Ribble Valley Borough Council  
Housing & Development Control

Your ref 3/2020/0911  
Our ref D3.2020.0911  
Date 24<sup>th</sup> February 2022

Application no: **3/2020/0911**

Proposal: **Proposed two-storey extension to rear and re-modelling of home and garden centre, including additional indoor and outdoor retail space and increased cafe area and play area.**

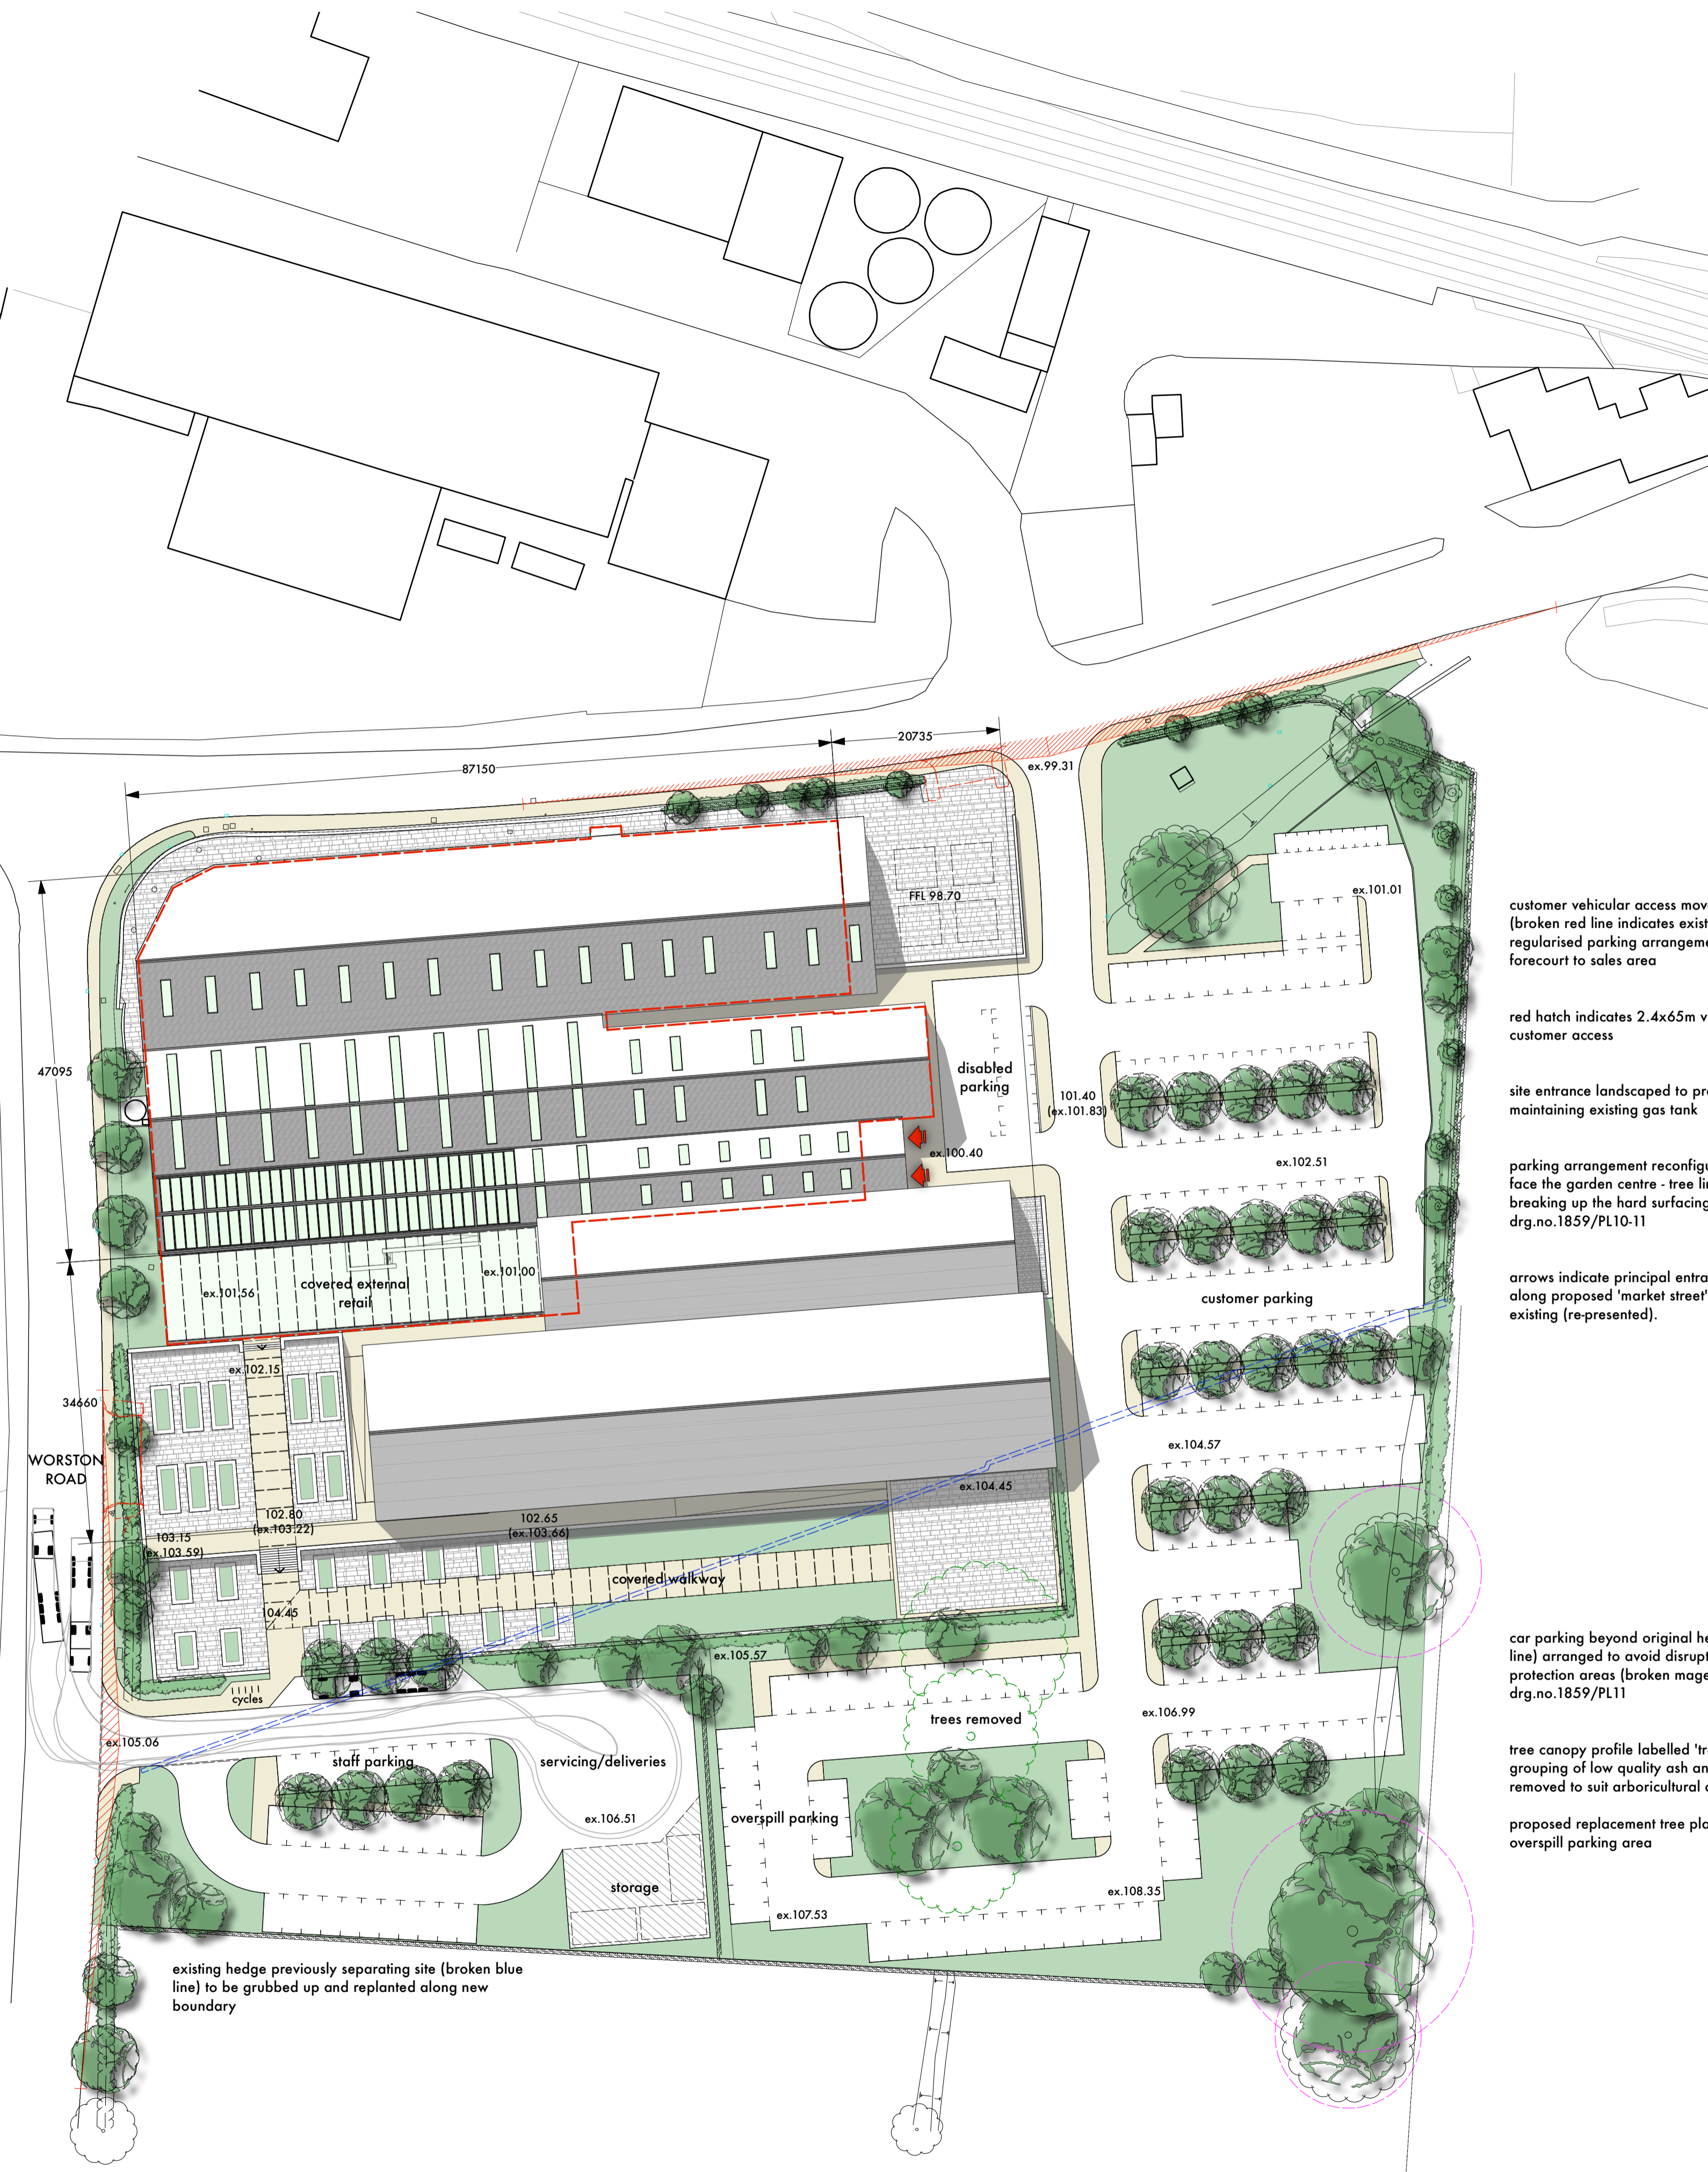
The LHA have reviewed the primary access which will be used to serve the car park, located off Clitheroe Road and are satisfied that the access arrangements complies with the LHAs guidance. The LHA also welcome that the access and the internal carriageway will only have two lanes, one "in" lane and one "out" lane, which the LHA advised in the previous highway comments dated 7th January 2022.

Furthermore, the LHA have reviewed the visibility splays shown on the drawing and are satisfied that the access can provide the minimum visibility splays for a 40mph road.

The LHA have reviewed Stanton Andrews drawing number PL.01 Rev E titled "Proposed Site Plan," and understands that the existing car park will be extended from 155 car parking spaces to 241 spaces, following the extension to the site. An increase of 86 car parking spaces.

servicing/staff entrance - refuse vehicle tracking (phoenix 2 duo - P2-15W with elite 6x4 chassis)

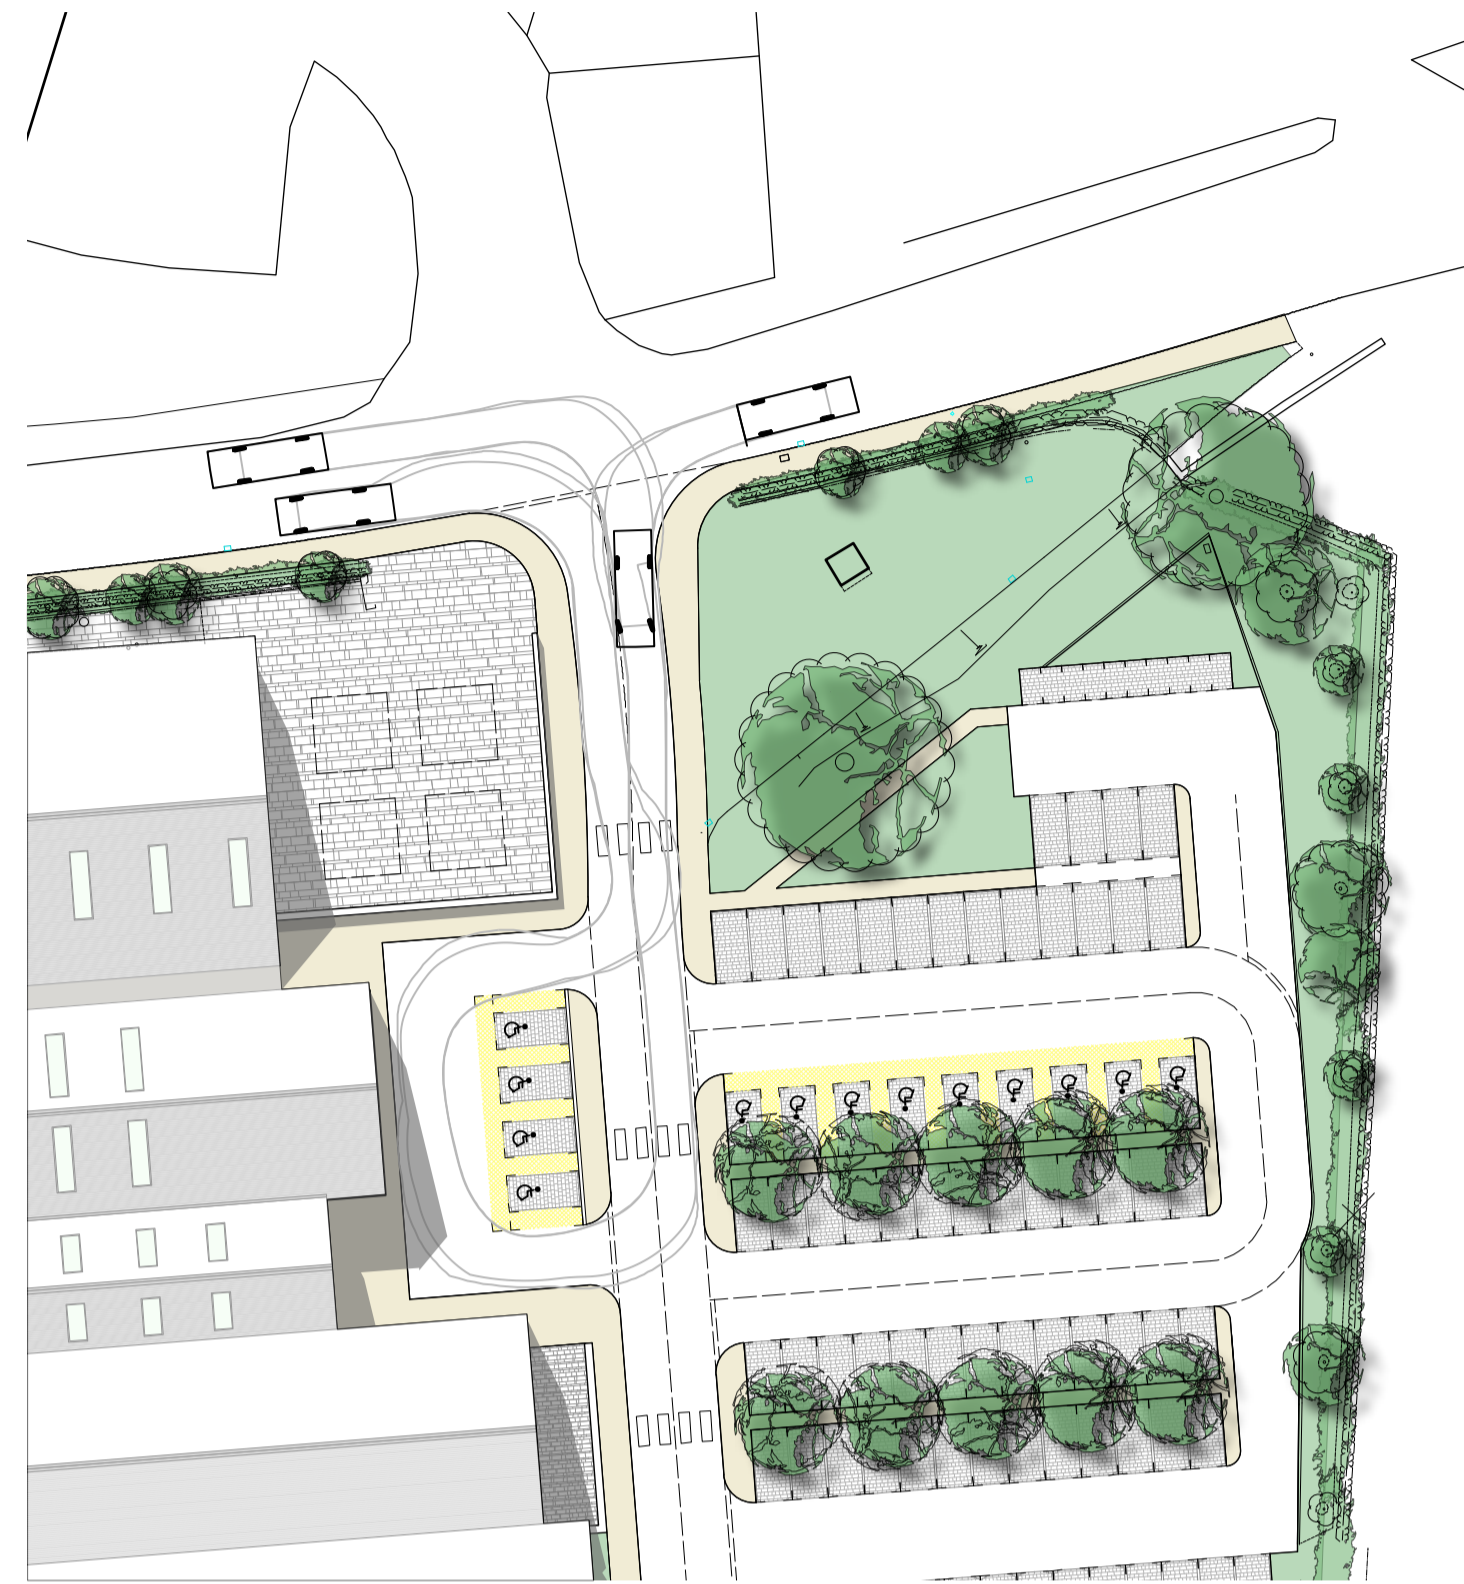
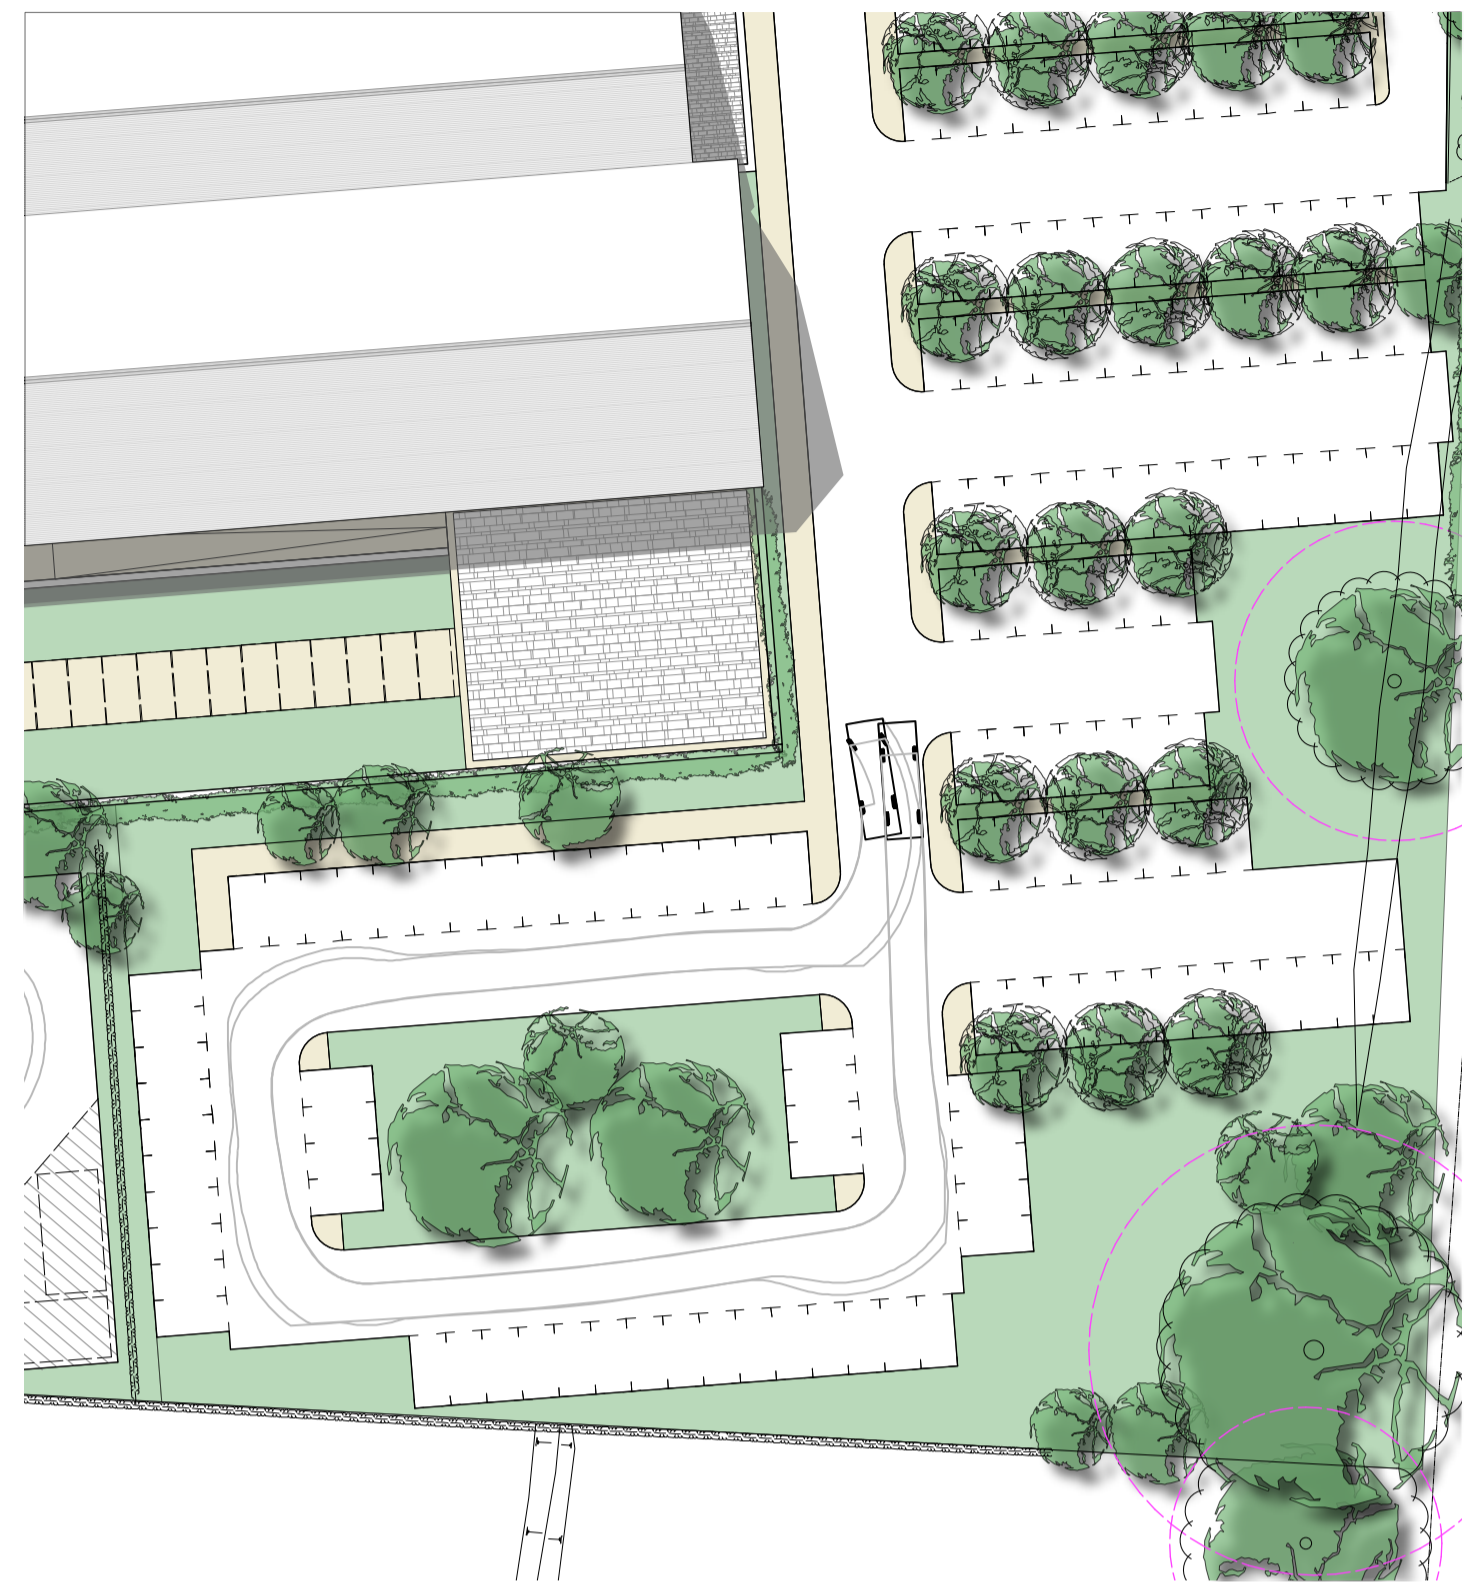
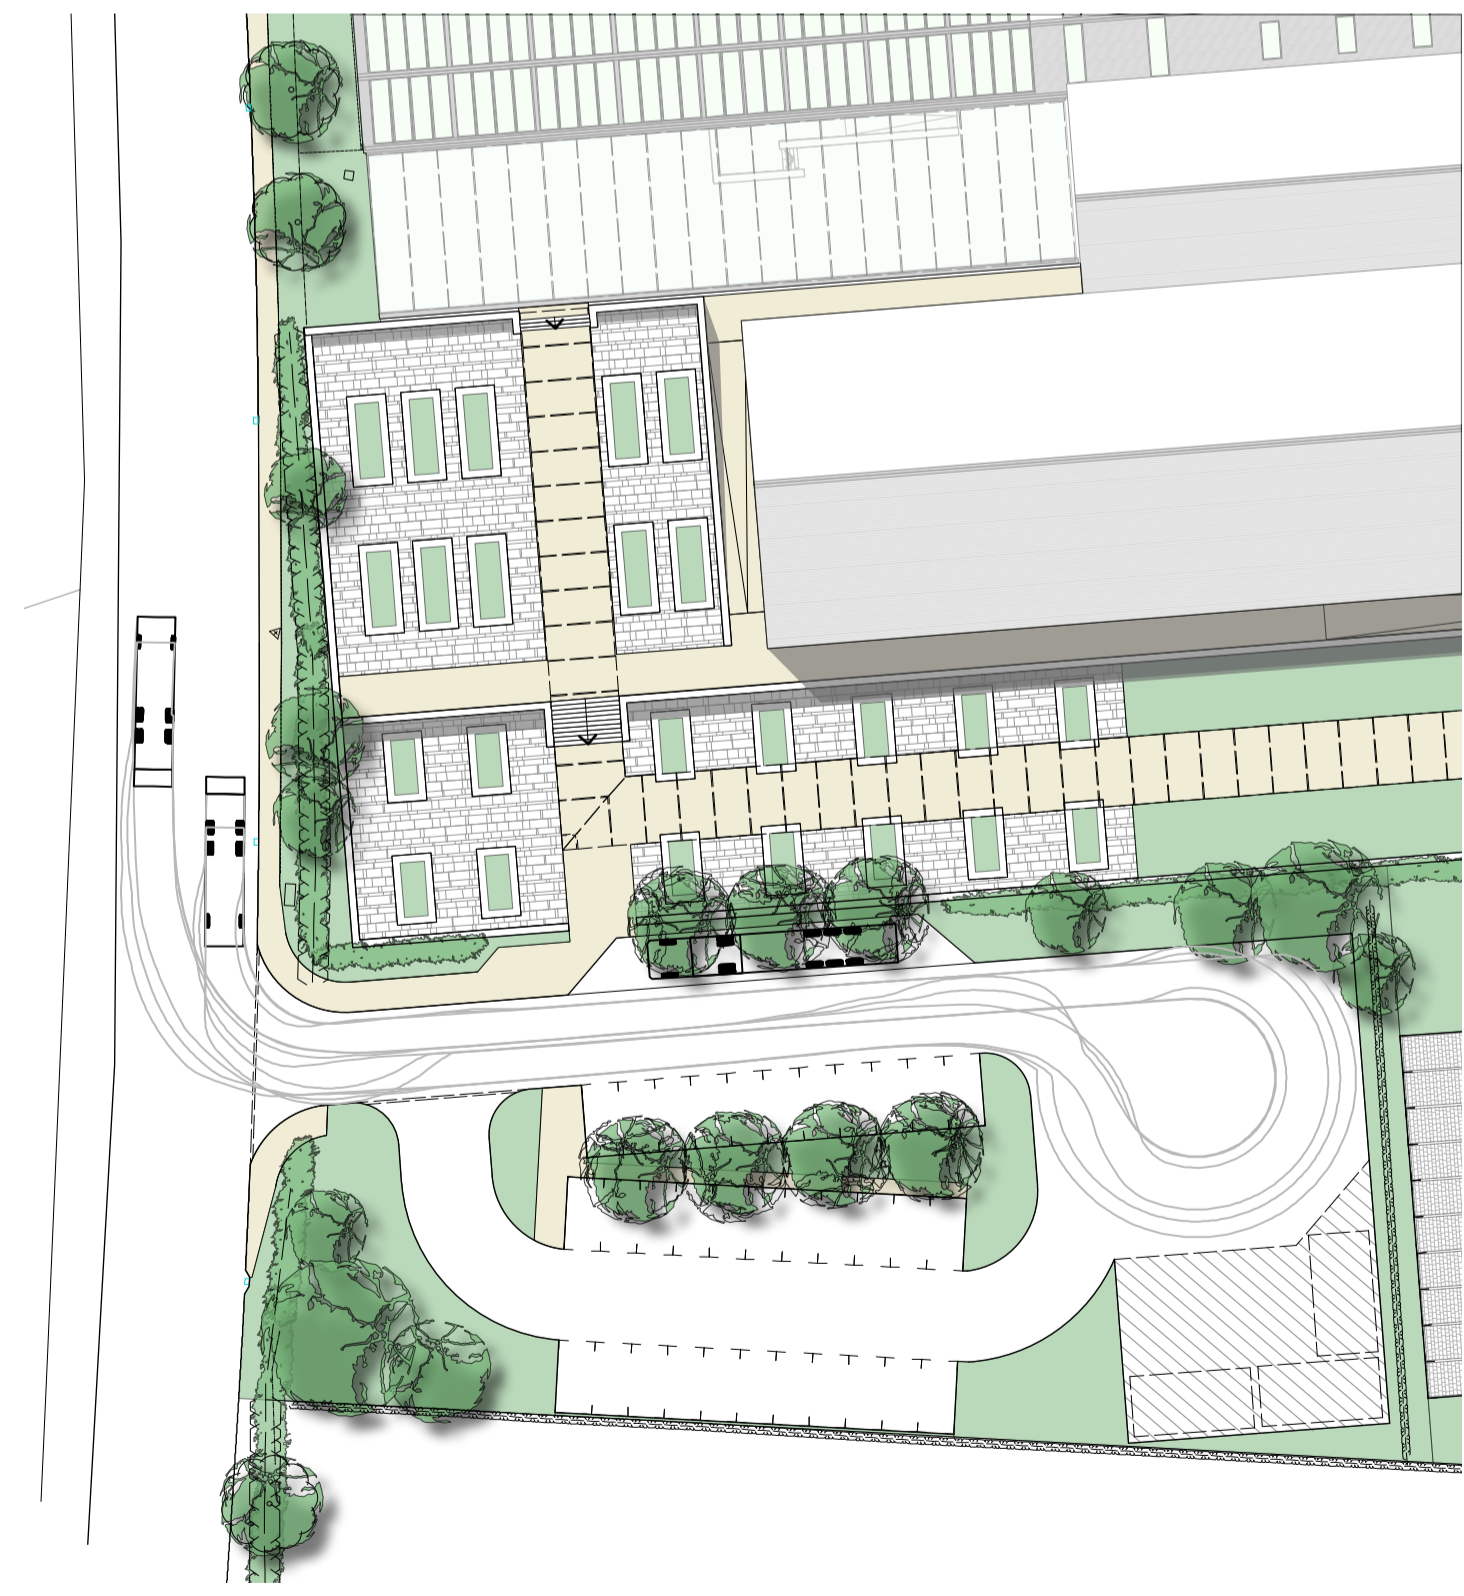
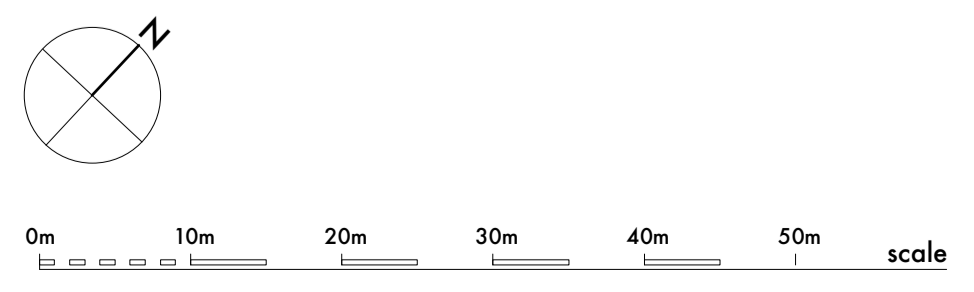
The LHA have reviewed Stanton Andrews drawing number PL.01 Rev E titled "Proposed Site Plan," and are still concerned regarding large, delivery and refuse vehicles using the access. This is because as shown on the swept path drawing, refuse vehicles turning left into the site from the public highway, are still extremely close to the footway located at the site access.

Refuse vehicles exiting the site and turning right onto Worston Road, are also extremely close to the grass verge and the footway as it exits the site. Therefore, as expressed in the previous comments dated 7th January 2022, the LHA require the site access to be widened to enable movements from large vehicles. This should be shown on a revised plan along with a revised swept path drawing.

The LHA require the secondary access to be redesigned to enable large, delivery and refuse vehicles to use the access safely without being close to any footways when undertaking turning movements. Therefore, should a revised plan be submitted quashing these concerns by widening the access, the LHA will have no objection to the proposal.
